**From:** [Neil Crowther](#)  
**Sent:** 04 August 2021 17:22  
**To:** [David Glover](#)  
**Subject:** RE: : PLANNING APPLICATION REF:EP/56/21/HH

RE: PLANNING APPLICATION REF:EP/56/21/HH

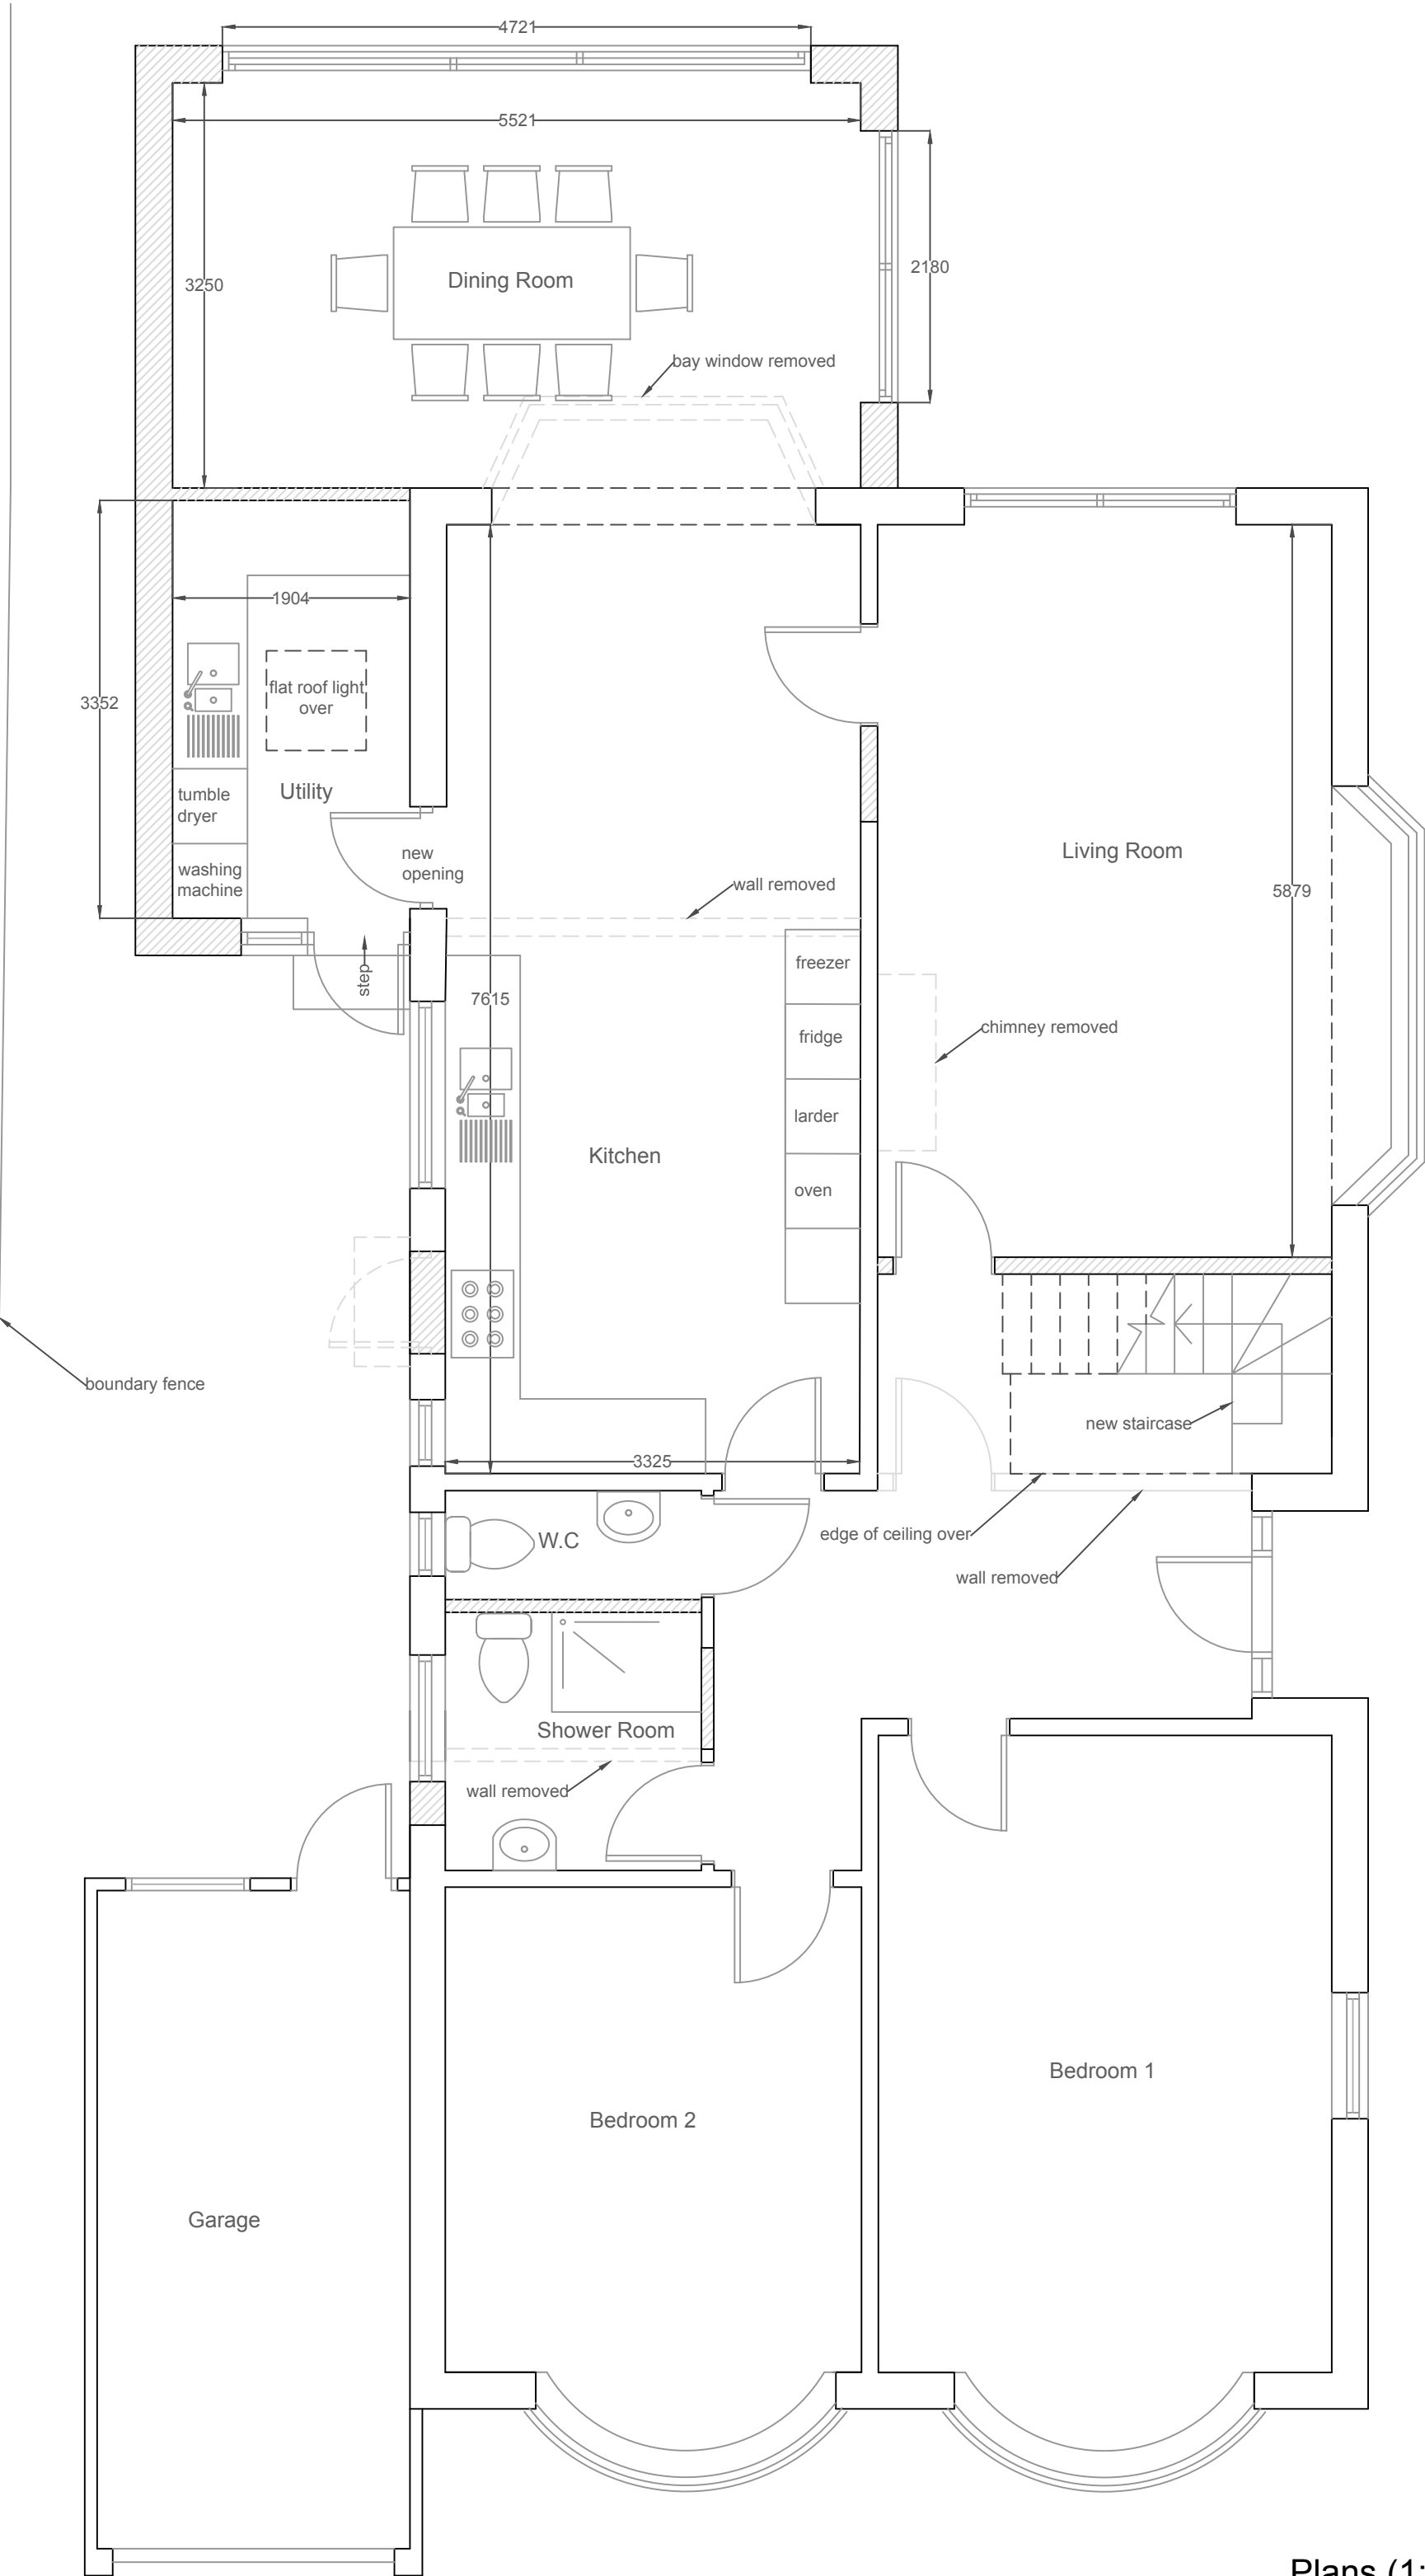
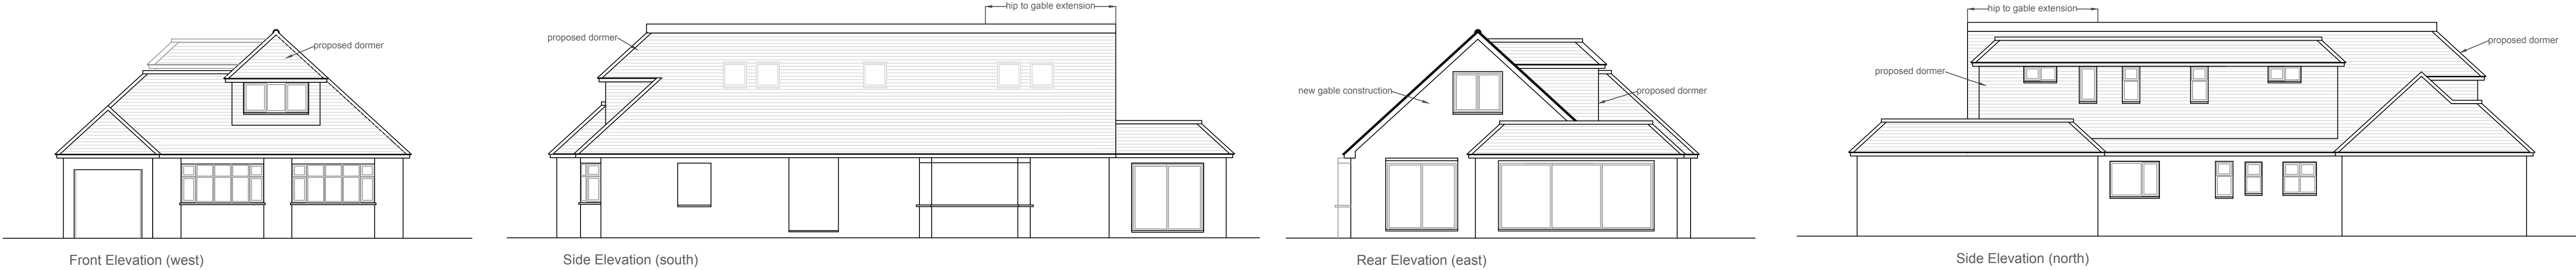
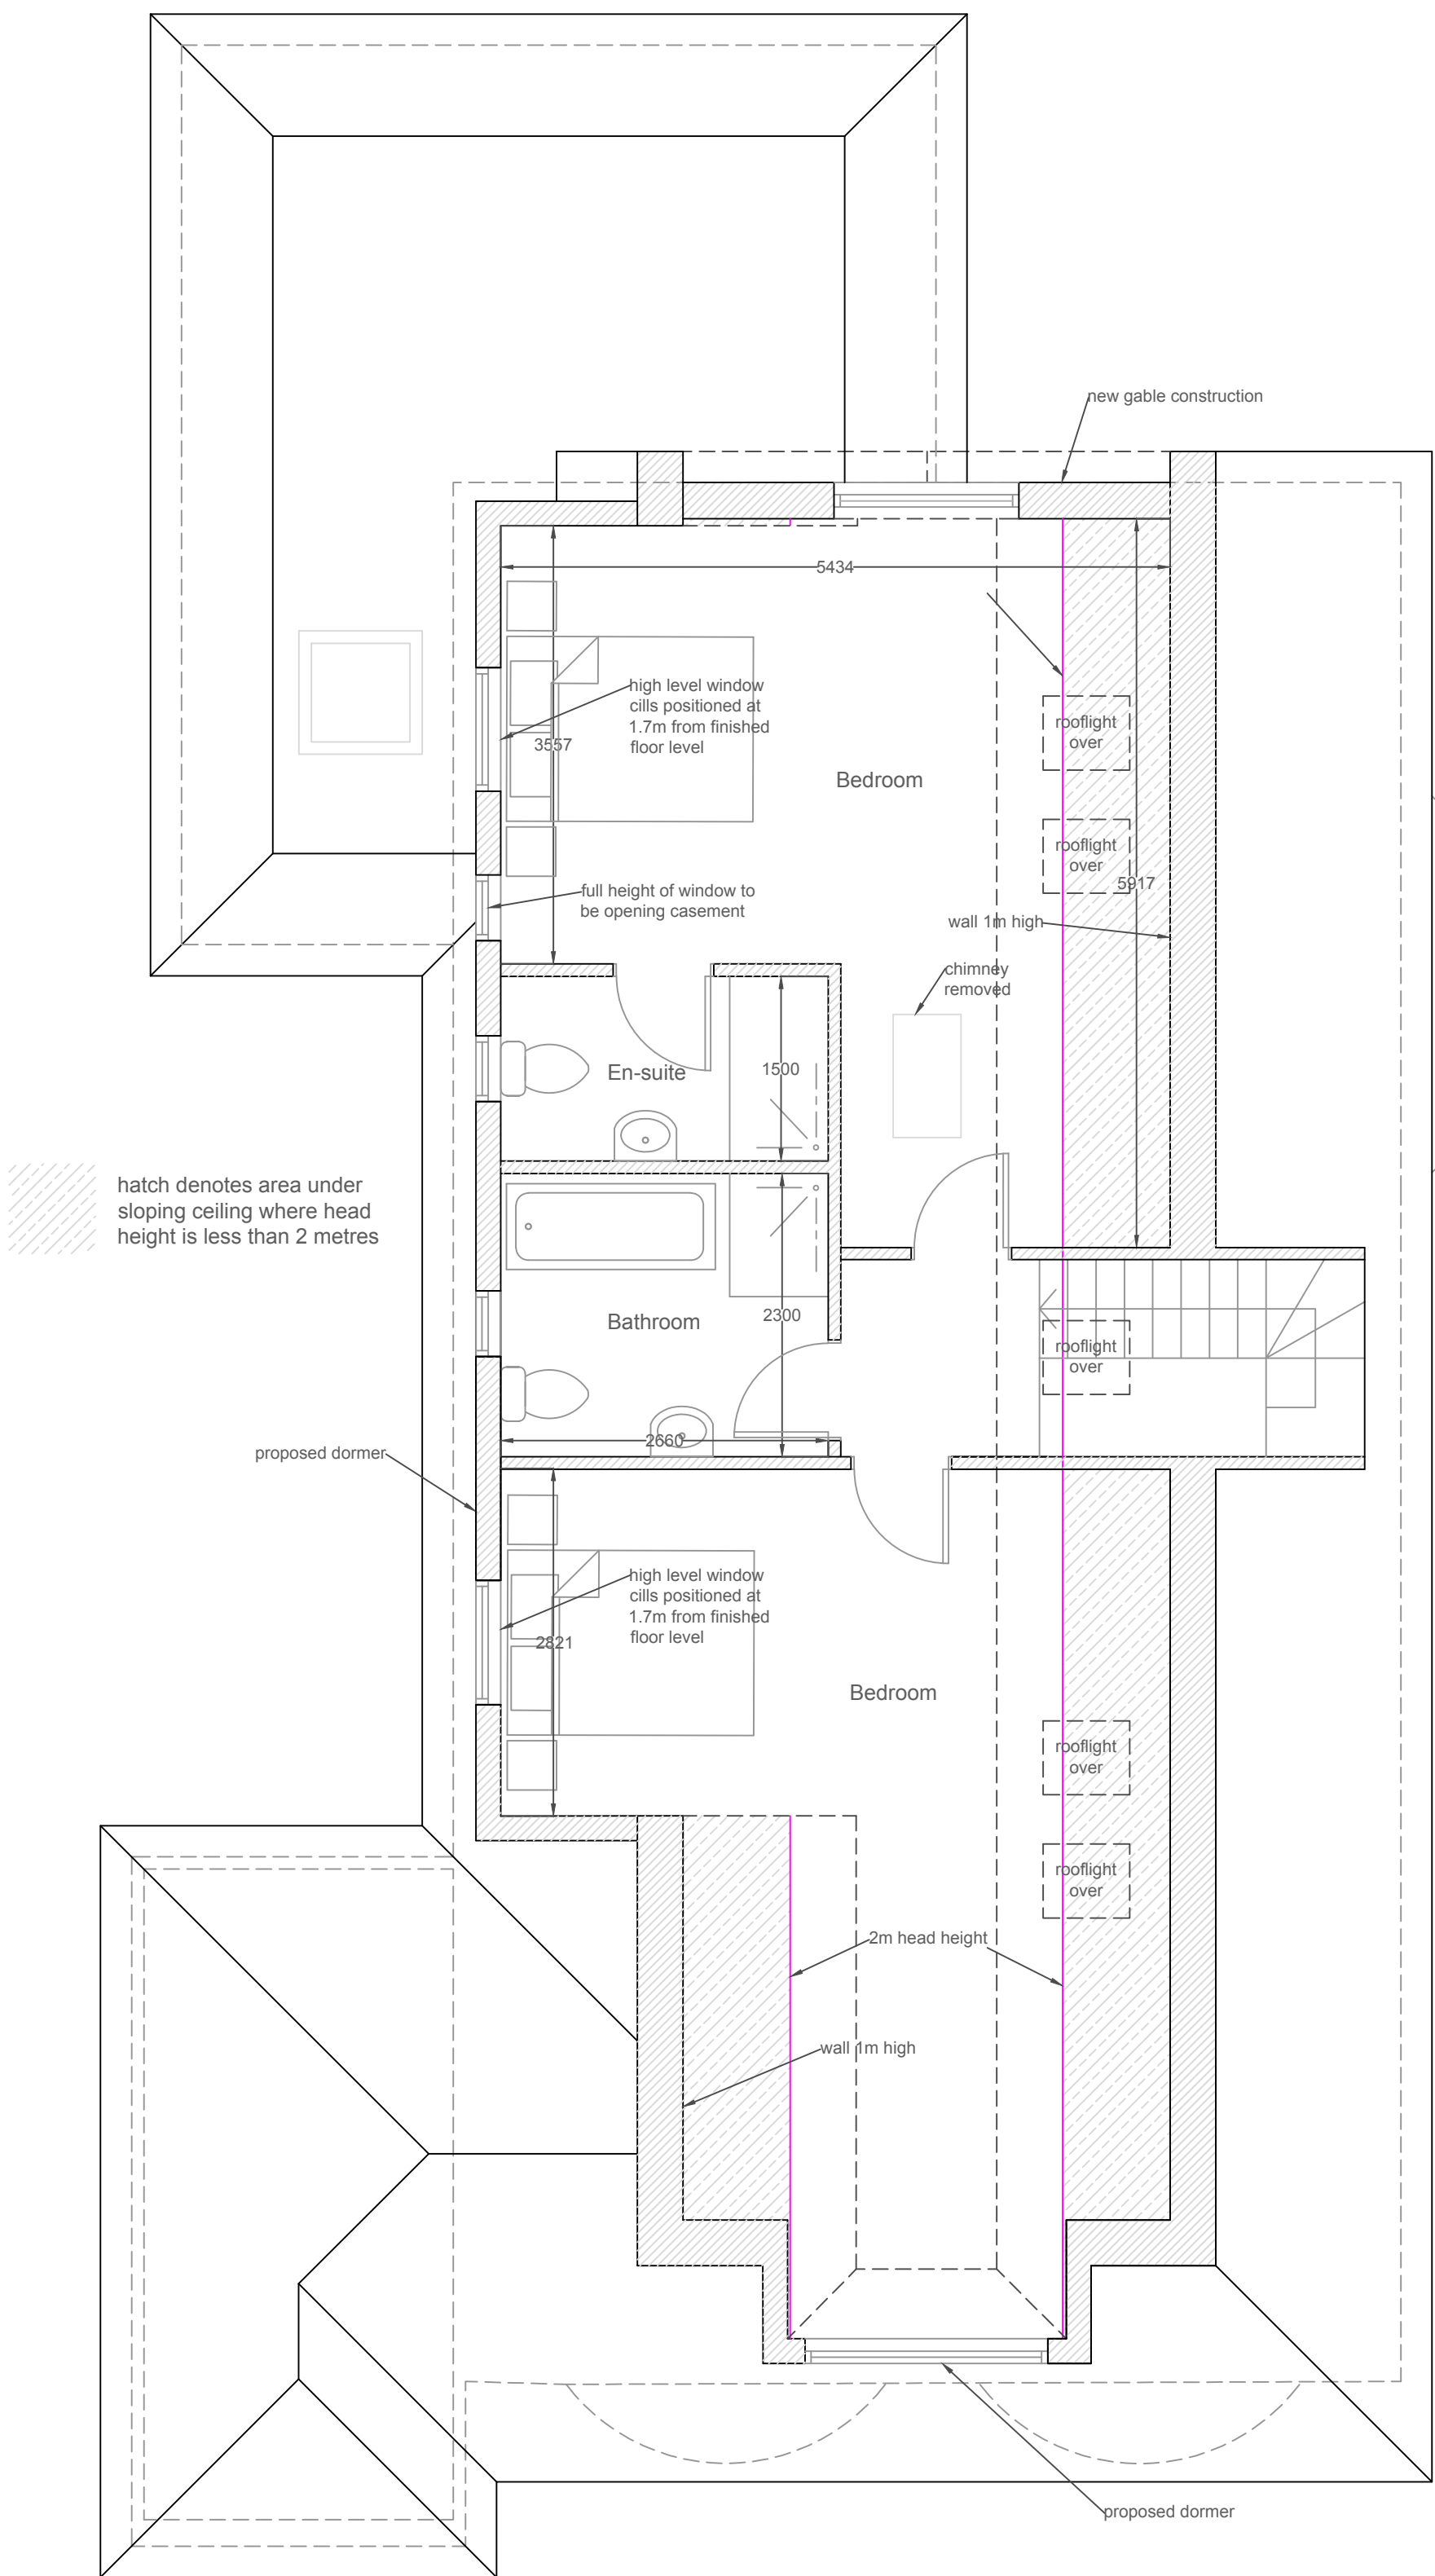
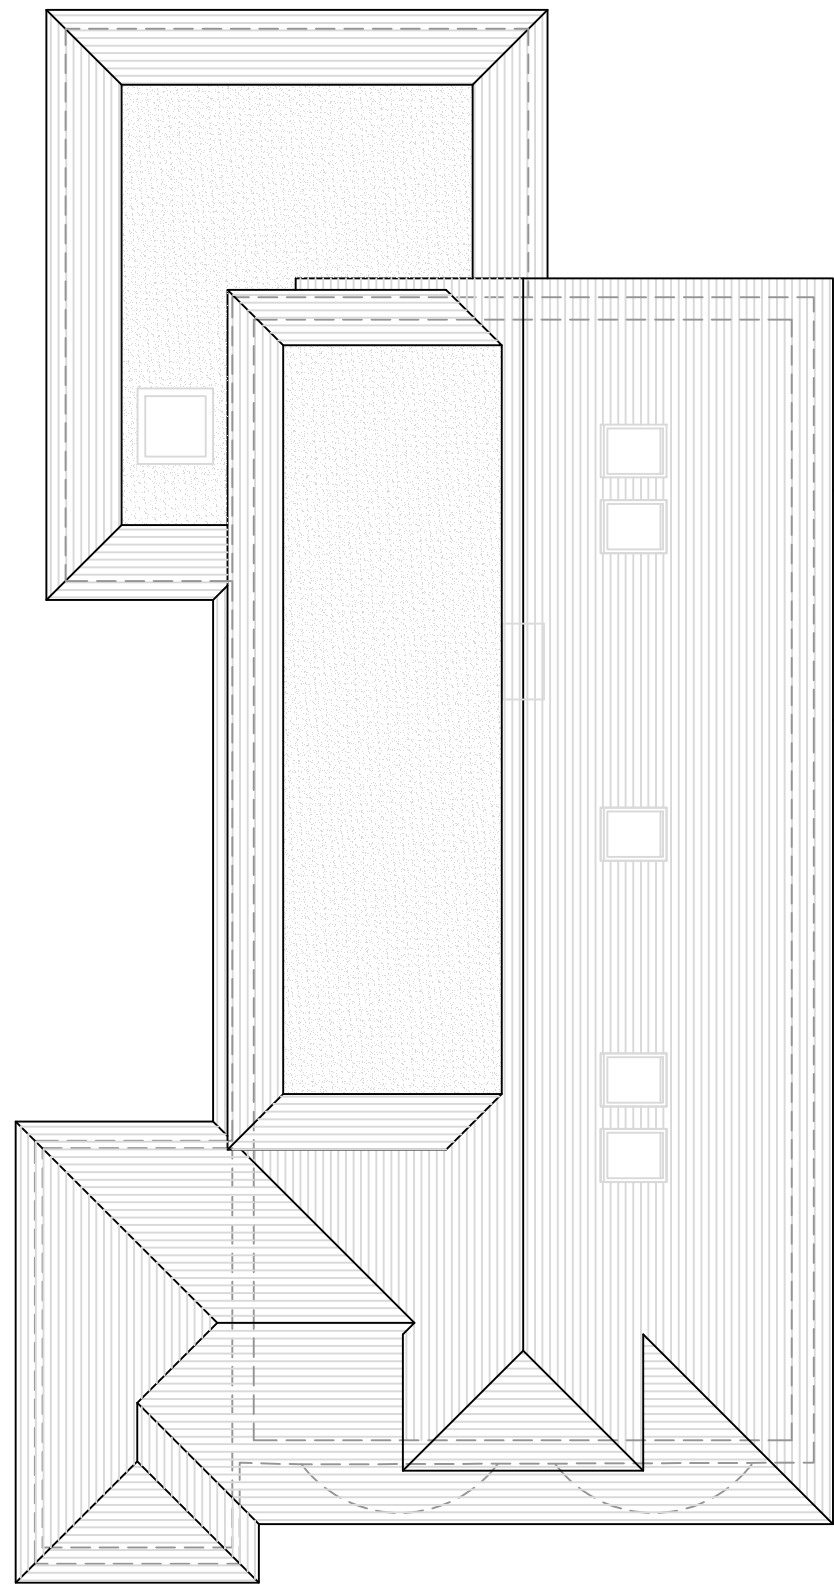
- 1) You say "what was proposed could pretty much be permitted development" and yet you accepted and acted upon it as a Planning Application. So what do you mean precisely?
- 2) "The only restriction on such a development is that windows are 1.7m above floor level", can you confirm that this is the case for all the windows as shown on proposed plan 1281.02.d?

understand the decision-making process that has been applied to the proposed Northern elevation. The opening casement window, and indeed all windows to this side of the property do not conform to the Councils own requirements. This could be considered overdevelopment of the plot as highlighted by East Preston Parish Council.

Returning to our privacy concerns. As stated in our objection, the distance from our Southern Boundary is approx. 82cm. Surely this proximity should have been considered at the decision-making process. Was it? It would seem that "a full height opening casement window" (as stated on plan) to be "completely obscurely glazed" would not be obscured in any way, shape, or form when open! This window would directly overlook my principal living space, both home and garden. This decision makes no sense at all. Perhaps you would care to comment on the rationale behind it?

The element of the proposals that you are concerned with – the side facing dormer window – could be built under permitted development rights. Permitted development is development that could take place without the need for any planning permission from the Council. However, this is often not simple so people apply to us for planning permission instead. In those cases, we will determine the application but cannot refuse permission for something that could be built as permitted development.

When determining applications we have to consider the requirements of planning policy as well as what could be built as permitted development – that is development that could take place without the need for any planning permission from the Council. In this case, a large box dormer window on the side elevation of a property could be built without the need for planning permission. The only restriction on such a development is that windows are 1.7m above floor level.

application, it was clear that what was proposed could pretty much be permitted development and we have sought to impose restrictions on the windows in the same way. Refusing planning permission for a proposal that is permitted development (and does not need planning permission) would clearly have been futile and unreasonable.
